# CITY OF ALBUQUERQUE

**RE: Del Webb @ Mirehaven Phase 2A  
Grading & Drainage Plan Revision 4  
Engineer's Stamp Date 3-11-16 (Rev. 4 Date: 08/17)  
Hydrology File: H09D017F**

Re: Revised Grading and Drainage Plan, Del Webb @ Mirehaven, Phase 2A – Design  
Revision #4 - Addendum #1 to Drainage Management Plan for Del Webb Phase 2 @  
Mirehaven Tracts M of the Watershed Subdivision - DRB Case No. 1006864 and  
Hydrology File: H09D017F.

DESIGN REVIEW COMMITTEE	CITY ENGINEER APPROVAL	LAST DESIGN UPDATE	MO./DAY/YR.	MO./DAY/YR.
CITY PROJECT NO.	ZONE MAP NO.	SHEET	OF	
		2	7

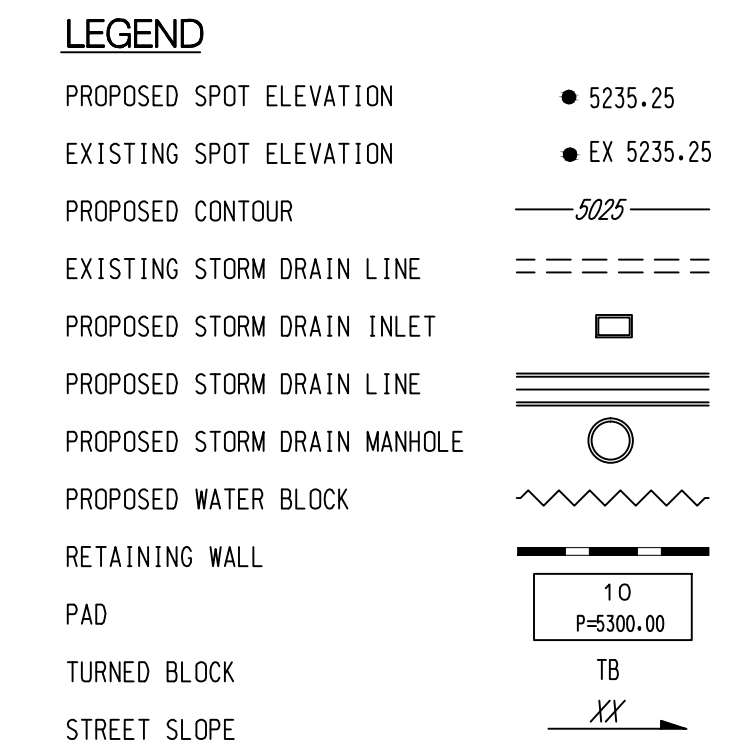
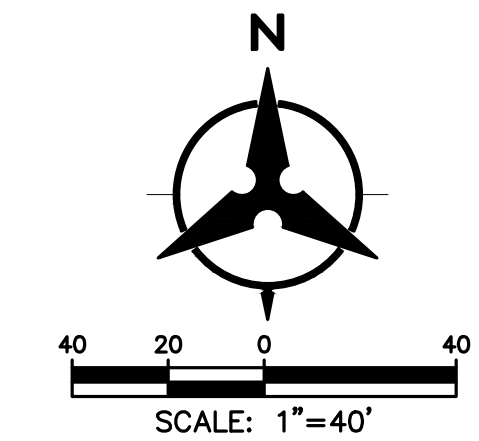
1. An Engineer Certified Addendum to the Drainage Report is required to support the new drainage pattern. The following should be addressed:
  - a. Proposed Basin Map: Basin G.5 will now drain into G.6
  - b. Geometry and hydraulic capacity of the new swale adjacent to lot 22.
  - c. Hydraulic capacity of the swale behind lots 16-22, accounting for the additional flow from G.5. This swale may need to be upsized.

In response to your letter dated August 21, 2017. Please find enclosed a revised Basin Map which shows Basin G.5 flow adjacent to Lot 22 and combining with Basin G.6. I have also provided update swale analysis to show the new swale adjacent to Lot 22, which is specified as a 5' wide, 1' deep swale of 1"-2" fractured cobble in Design Revision #4. In additions, I have also provided updated swale analysis for the swale behind lots 16-22, which the plan shows as a 7' wide, 1' deep swale of 1"-2" fractured cobble. In these swale analysis, it shows that the depth of flow based on the addition of Basin G.5 is still within the limits of the designed cross-sections mentioned above. There are no adverse affects with rerouting of Basin G.5 along Lot 22 with a new swale or having combining with Basin G.6 in the existing swale behind Lots 16-22.

5' wide channel 1' deep = side  
slopes 40% Q= 3.1cfs (Basin G.5)  
Q100=3.1 cfs < Qallowable=6.06cfs
